# ENG-PUDSP21005-R1-PUDSP.pdf Markup Summary

**Subject:** Text Box  
**Page Index:** 1  
**Date:** 6/4/2021 10:12:08 AM  
**Author:** dsdparsons  
**Color:** ■  
**Layer:**  
**Space:**  
**Page Label:** [1] WB PLP amendment 3.10.21-Cover

**1**

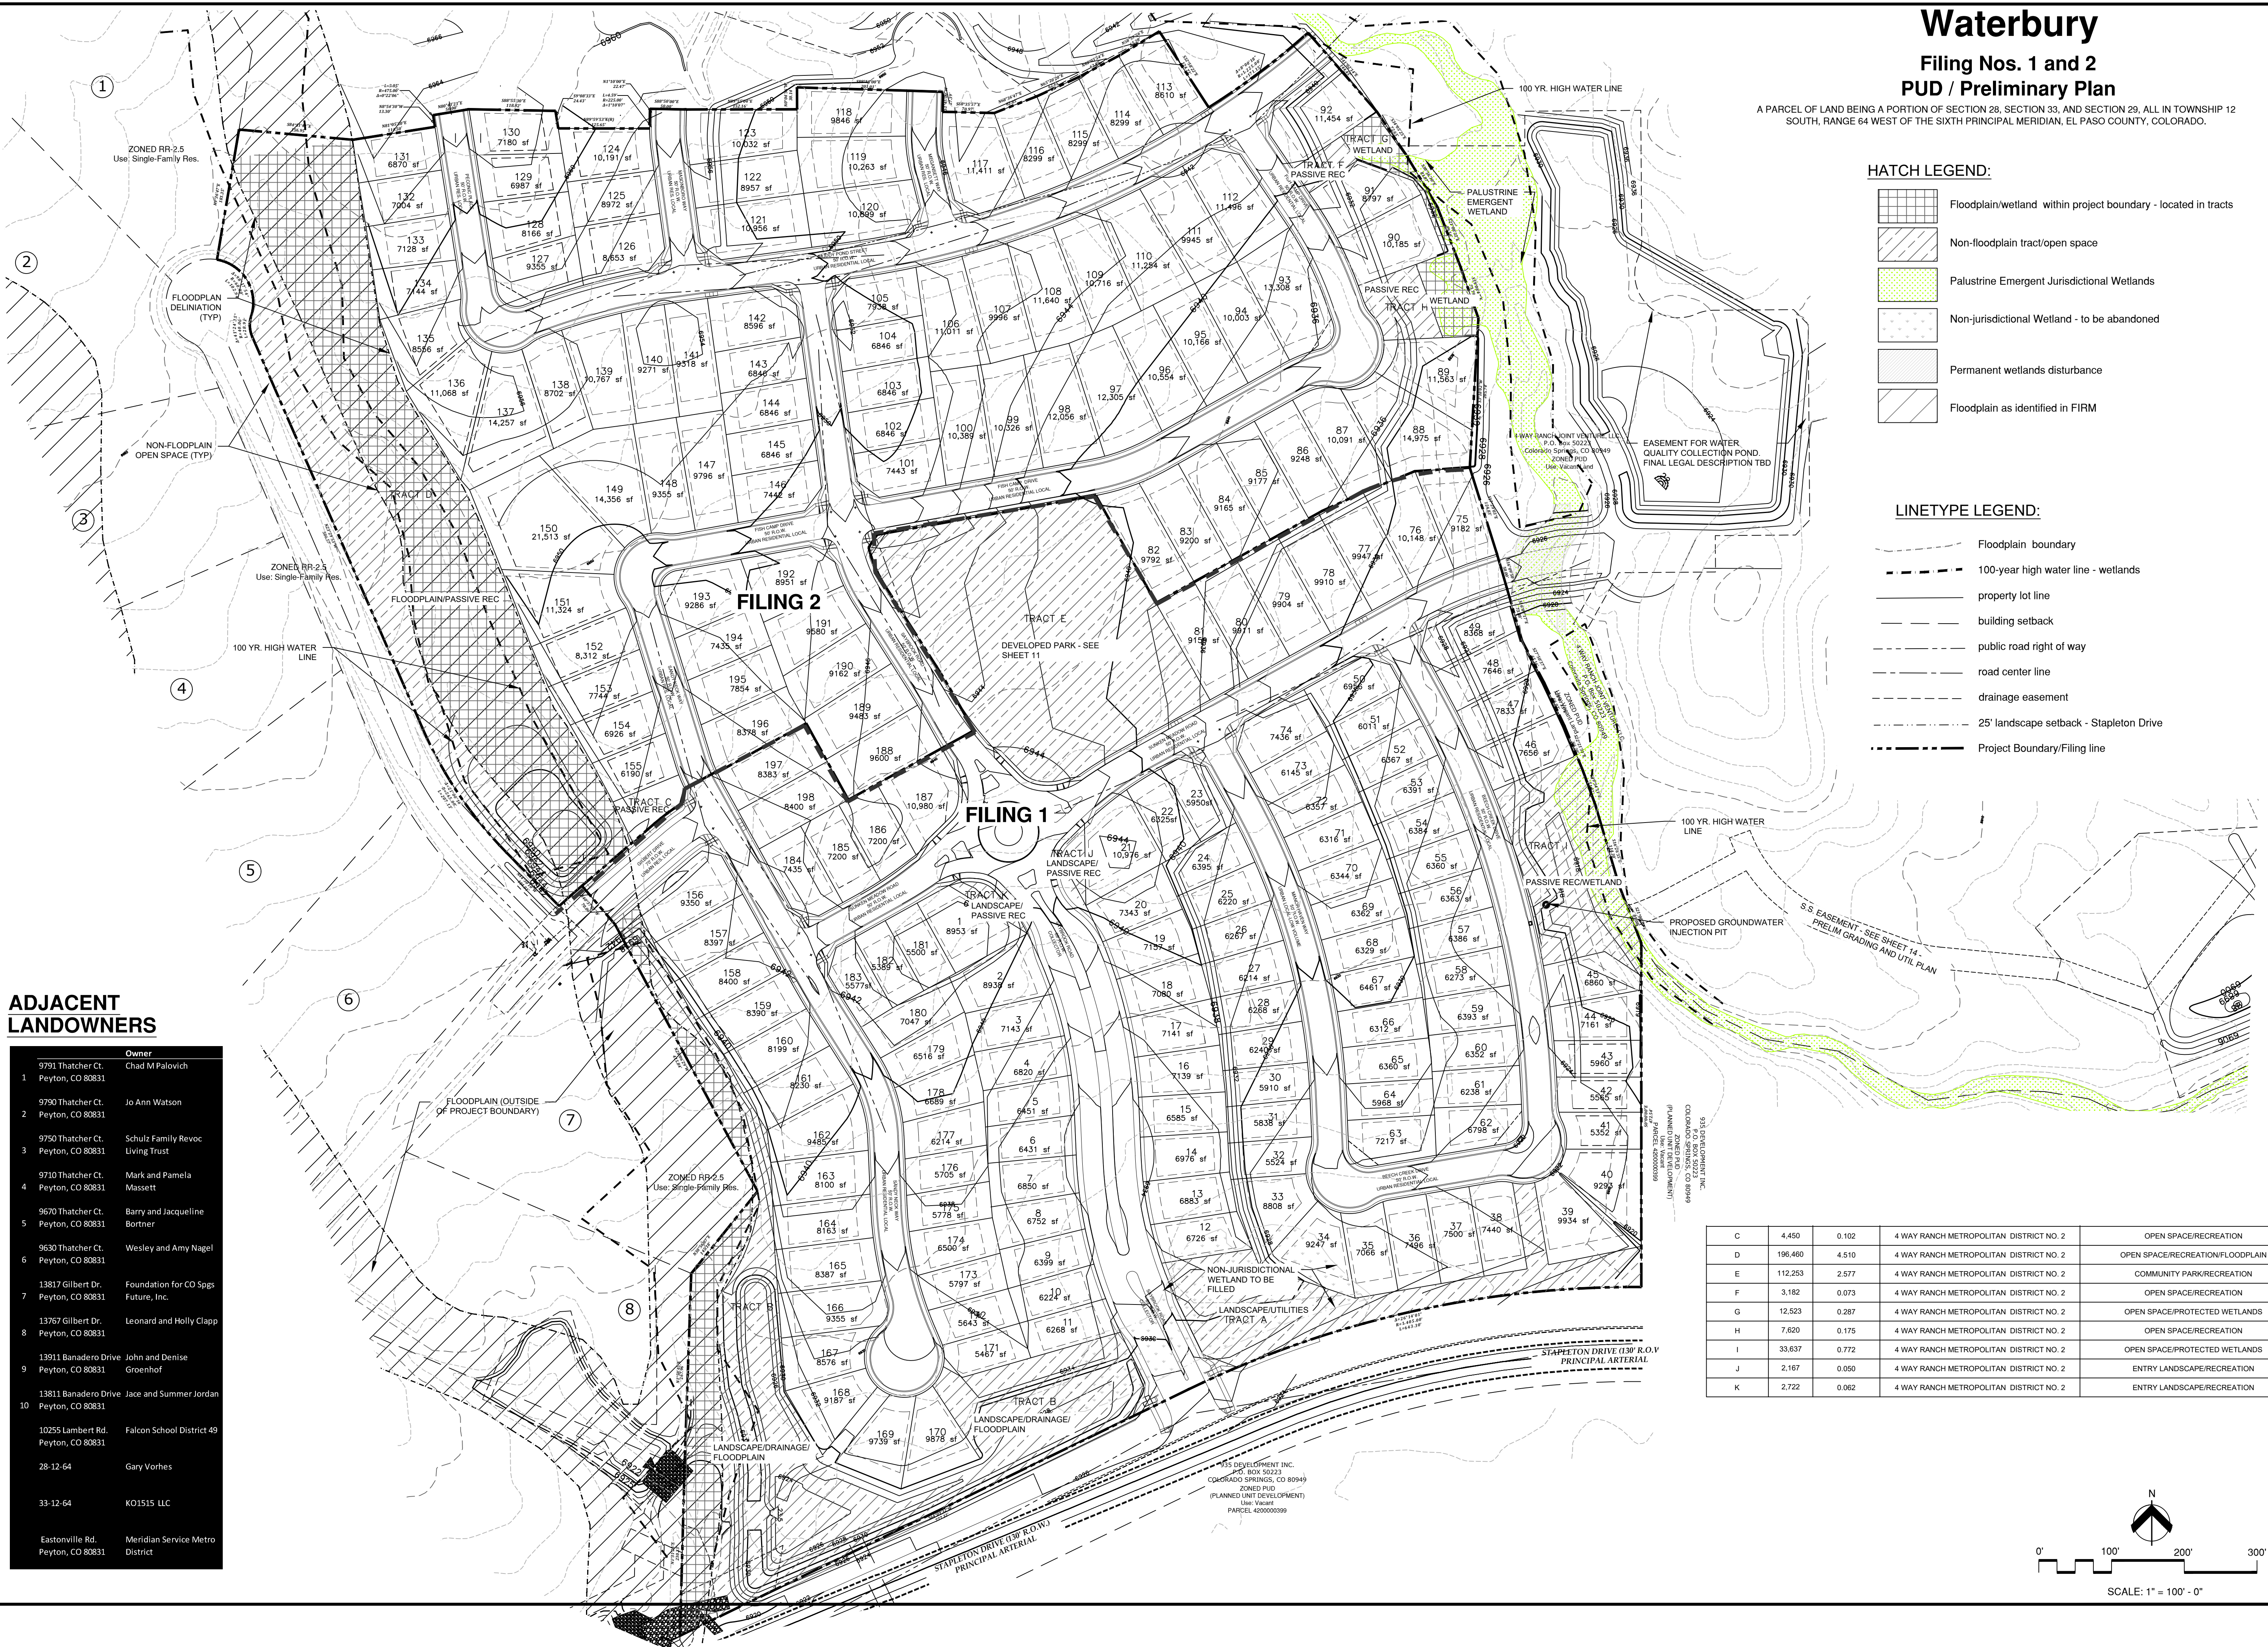
DELETE- Only one legal is needed; the legal for the boundary of the PUDsite-specific PUD

title to be unique so state title specifically please

delete NET density- we calculate density in context of dwelling unites divided by overall acreage

so this entity will keep owning these tracts after the development has occurred? That seems incorrect. A district or HOA is likley to own and maintain

delete this it is just confusing- keep this PUD specific to this 61.9 acre development

what is this? is this future development? are you including this in the legal for this pud 61 acres? ONLY show the BOUNDARY of this PUD-

re-title this Phasing Map and show the filings here \* filing lines subject to change with out PUD amendment, remove the filings from the other pages so you are not stuck. elete all the land not in this PUDSP 61 acres- it is not relevant and just adds confusion

draw a line between the filings

there should be a table for the PUD Modifications: It should site the Code requirement, than what your proposing , and than one of the criteria in Chapter 4, 4.2.6 you are using to justify modification. Modification of Existing LDC or ECM Standard. For approval of a modification of a general development standard in the LDC or criteria or standard of the ECM, the BoCC shall find that the proposal provides for the general health, safety, and welfare of the citizens and at least 1 of the following benefits:

provide a wide enough public improvements  
 easement for the sidewalks

Provide the standard easements note (widths and  
 maintenance).

SHEET TITLE:  
**NORTHWEST AREA DEVELOPMENT PLAN**

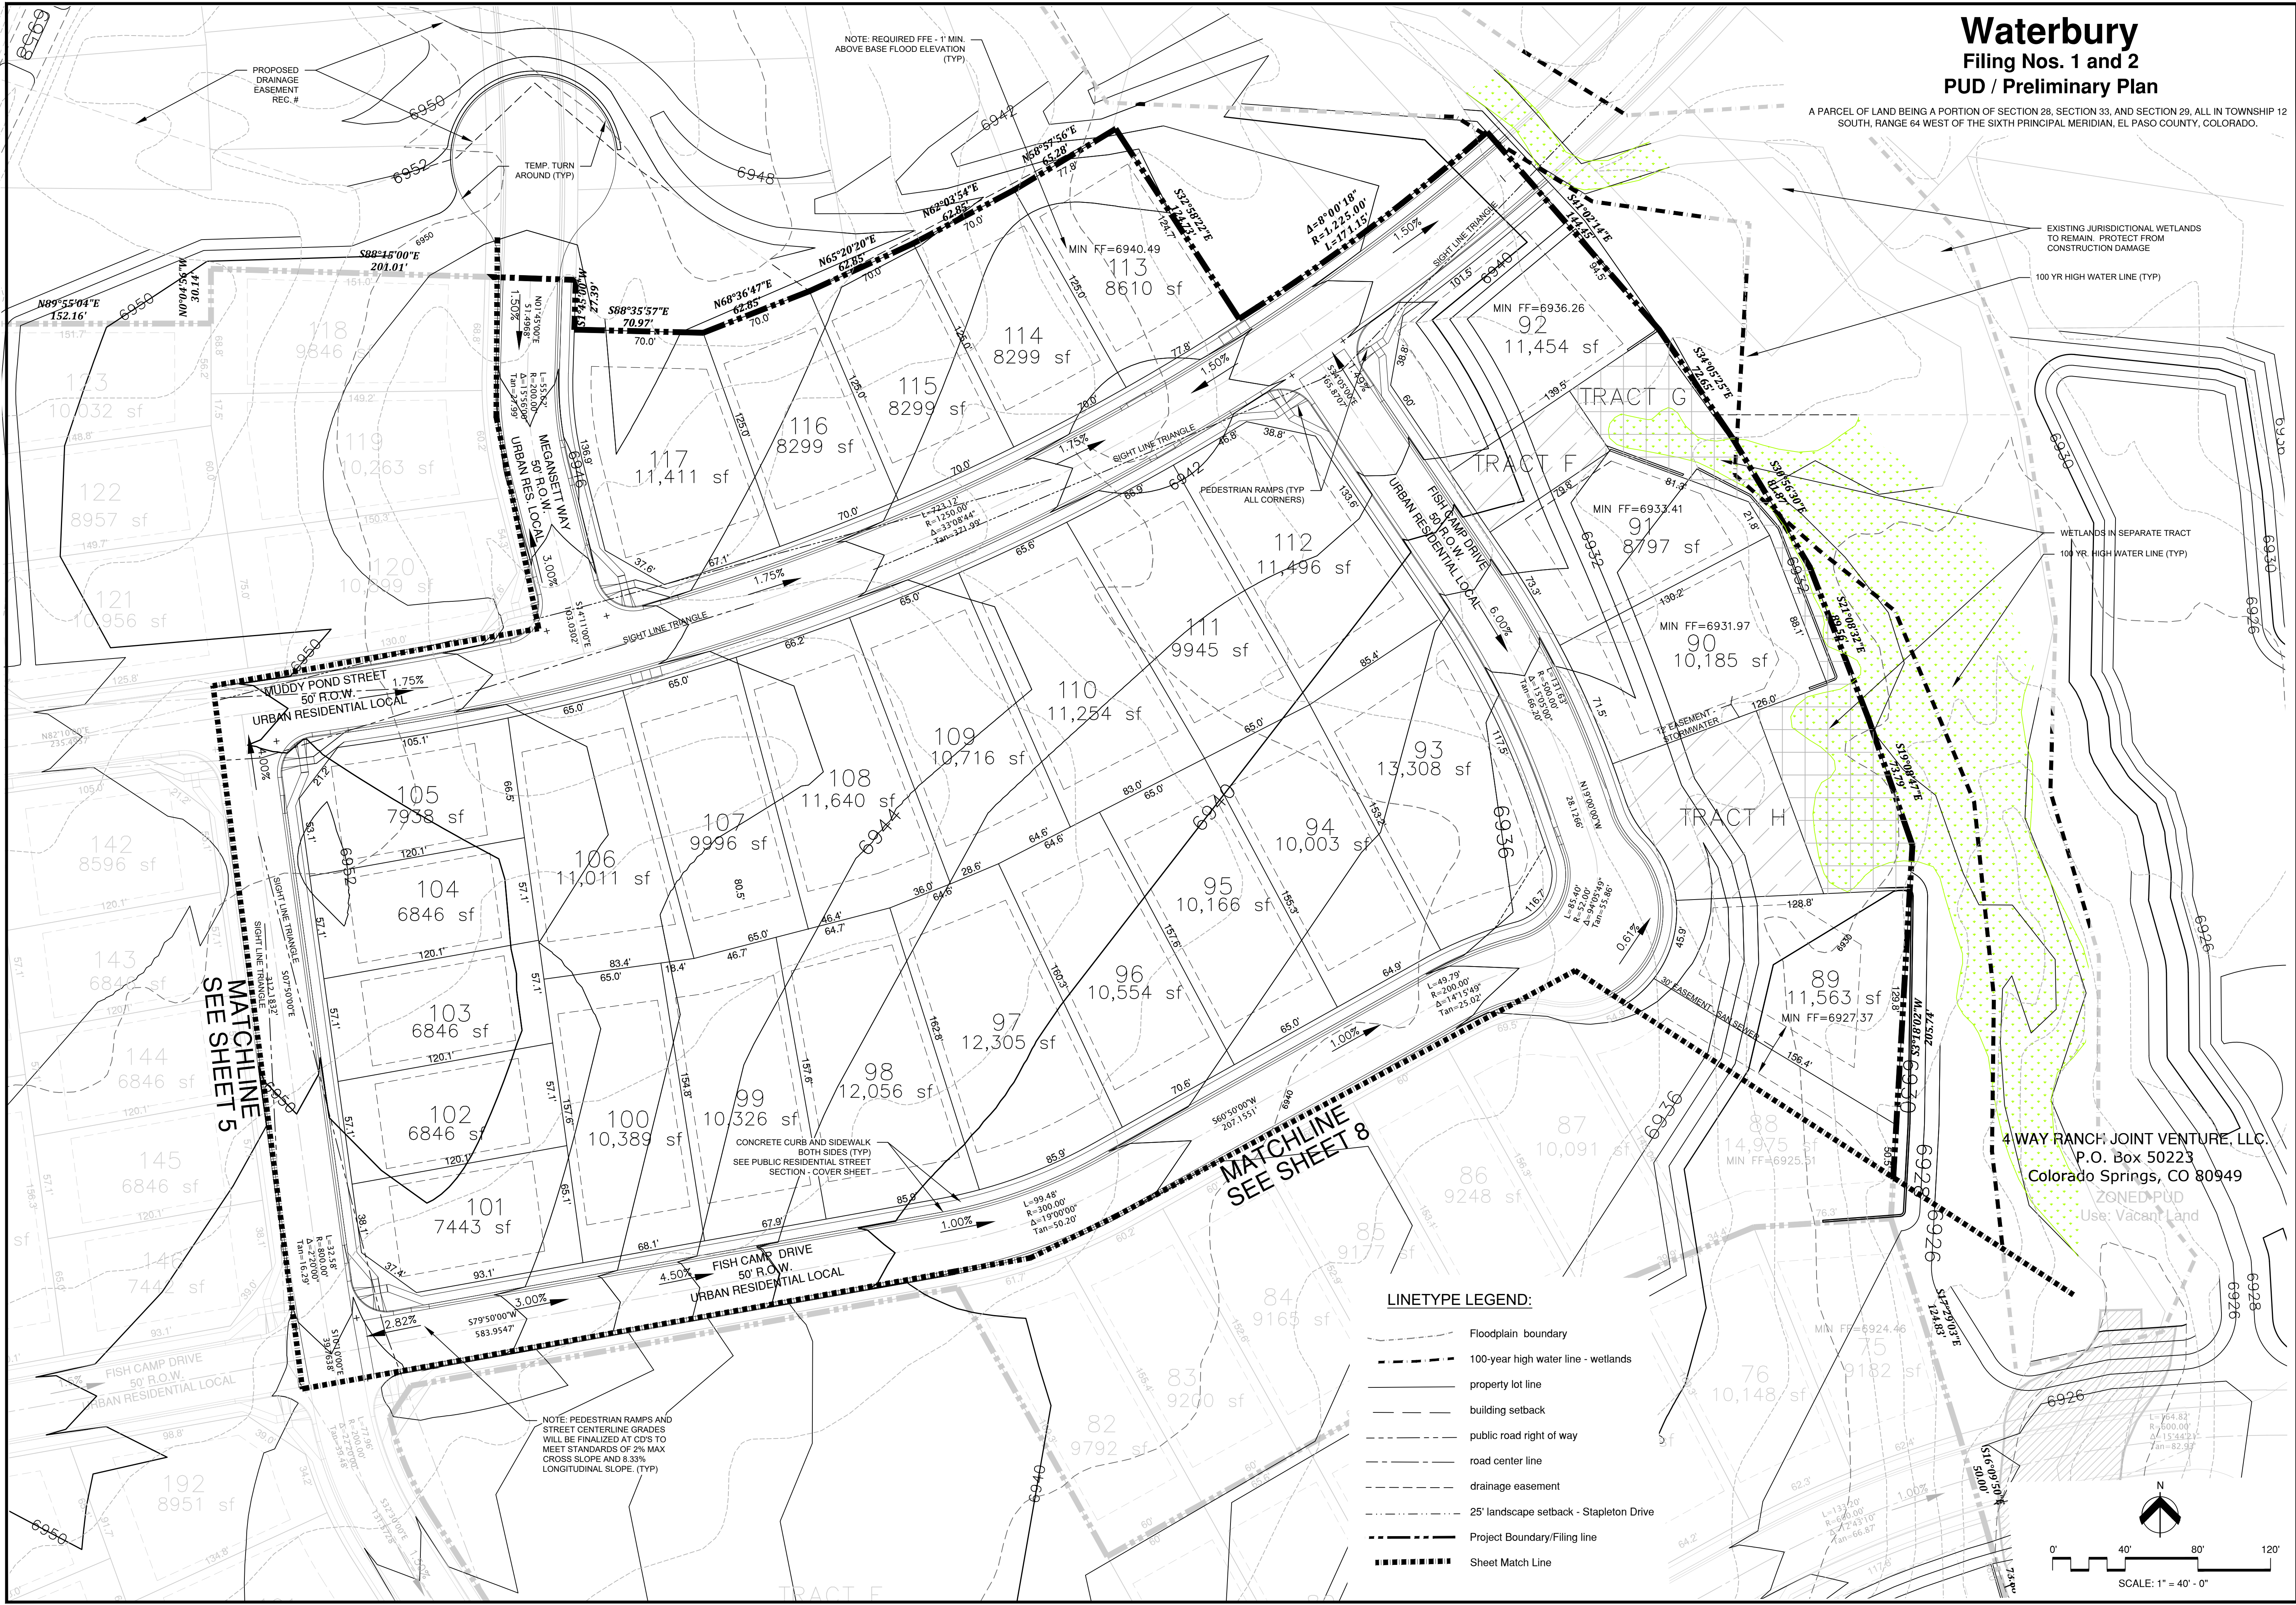
Breach stock pond?
